Your ref. EP/48/21/HH

We are writing in objection to the planning permission for a first-floor dormer to 2 Bay Tree Gardens, East Preston. Our property backs onto the afore mentioned property, to the west.

Proposed Materials:
Roof Tiles - Black tiles t.b.c
Walls - Thermowood charred timber cladding and painted render
Dormer Walls - Thermowood charred timber cladding

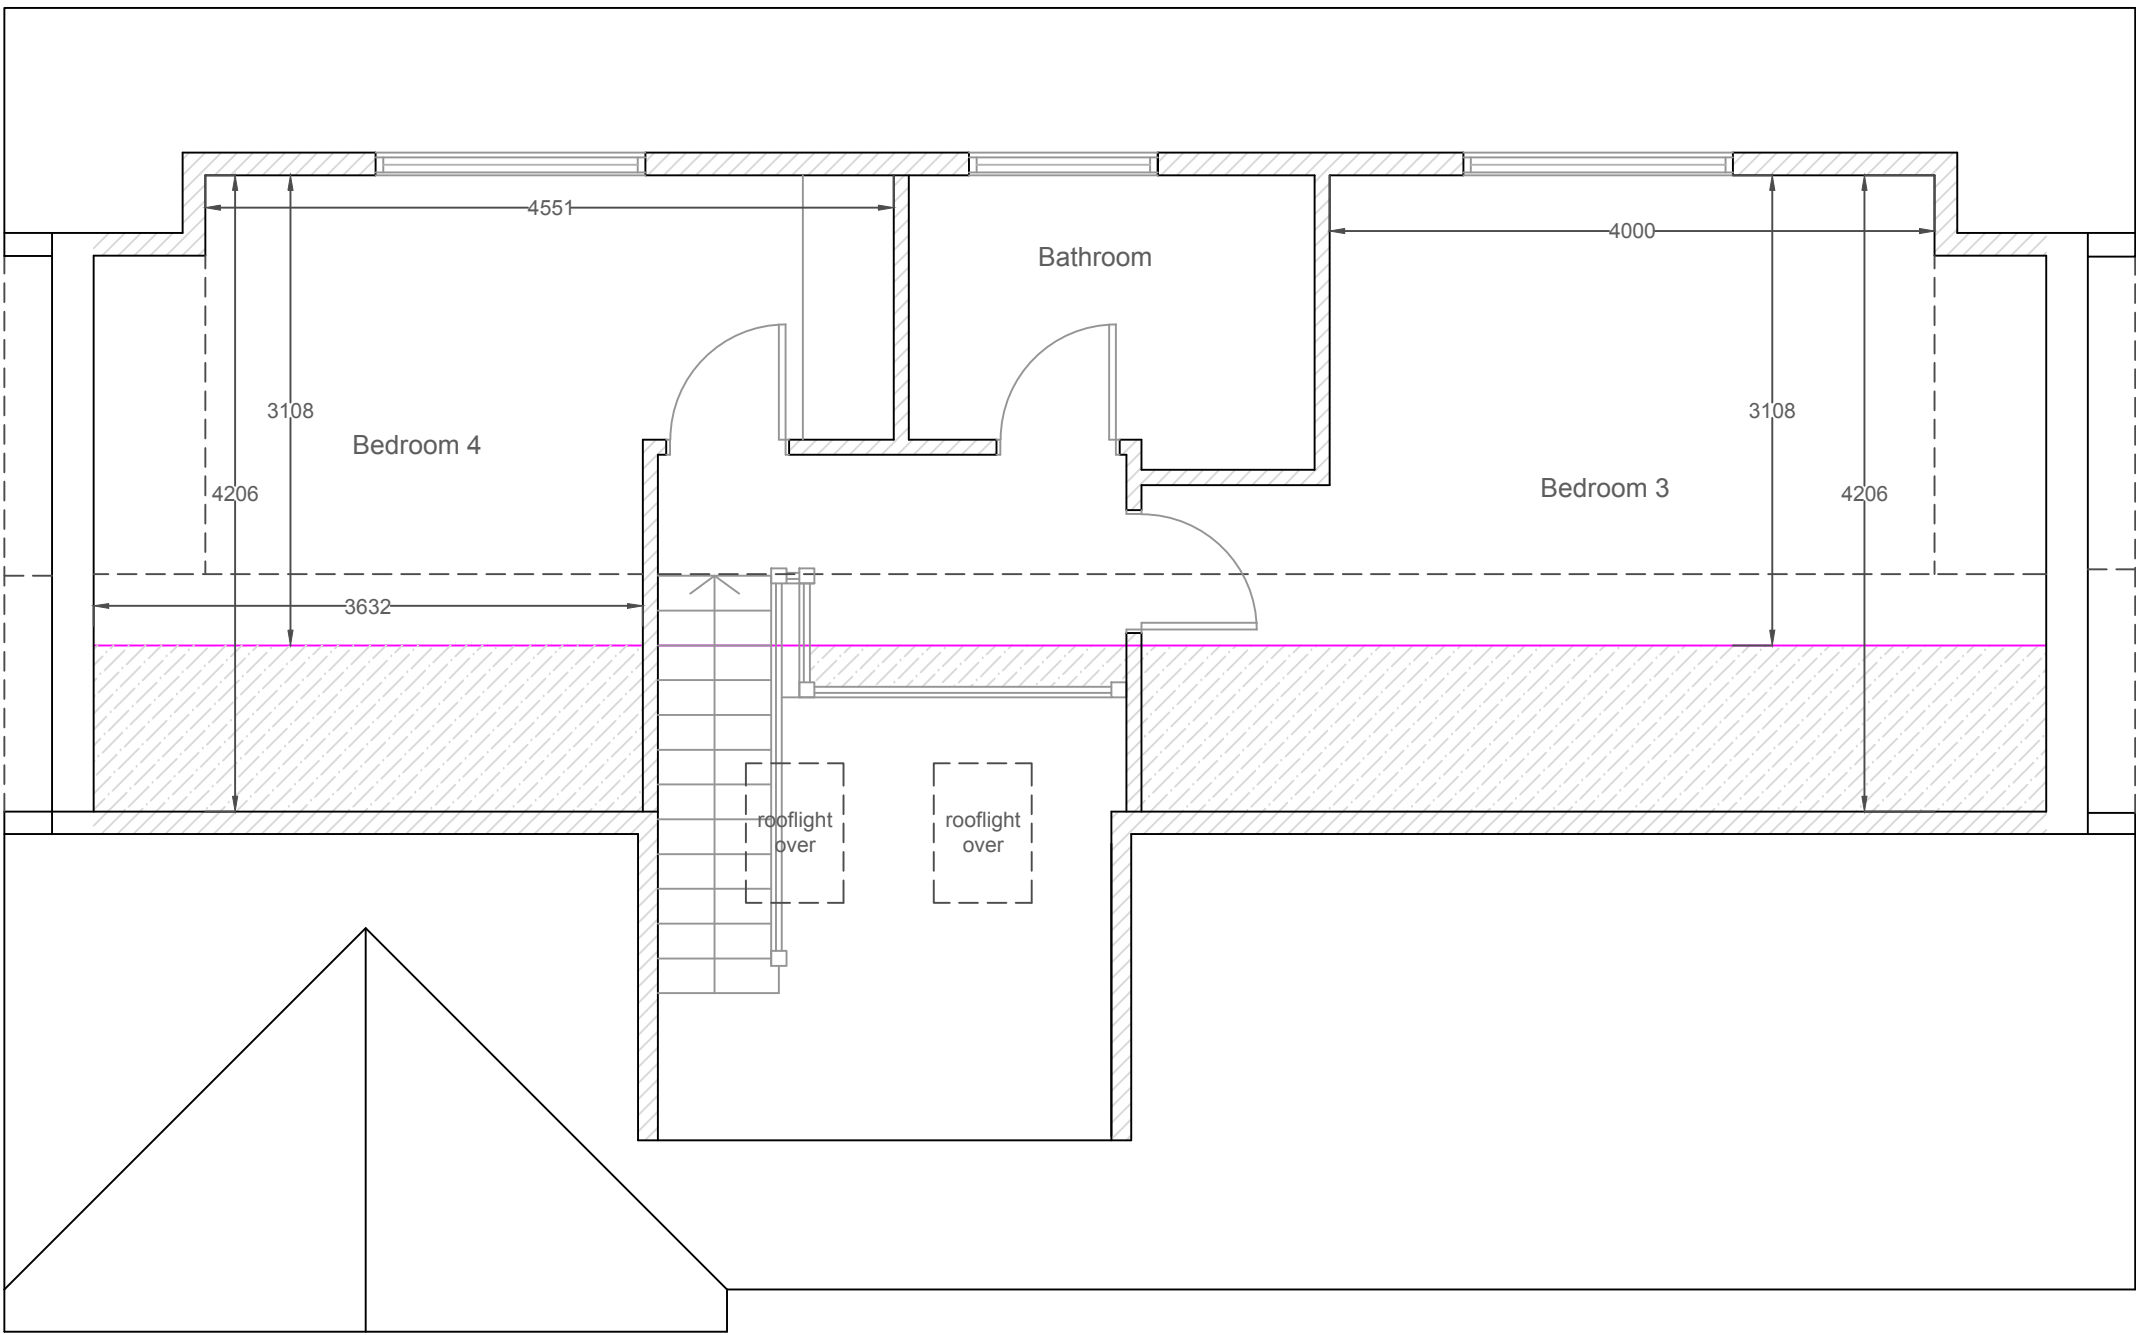
The proposed design of the dormer will overpower the look of the surrounding area due to its size and colour. The cladding of a black burnished wood and black roof tiles are not in keeping or sympathetic with the materials currently used on the external walls of the surrounding dwellings. Surrounding properties have traditional tiled roofs and tiled dormers, with red brick walls. Any deviation from this style, such as the proposed white rendering and black cladding would be in violation of Design Policy 4 of the East Preston Neighbourhood plan for Area 3, which states that:

The proposed dormer is oversized and includes unobscured windows that would look directly into our conservatory, dining room, kitchen, and master bedroom. In addition, it would overlook an established decking area at the bottom of our garden, which the

The proposals to raise the roof would make the property stand out in the row of three bungalows and would not compliment the scale or massing of the surrounding buildings. Therefore, the proposed extension to 2 Bay Trees Gardens is in conflict with Policy D DM4 of the Arun Local Plan 2011-2031.
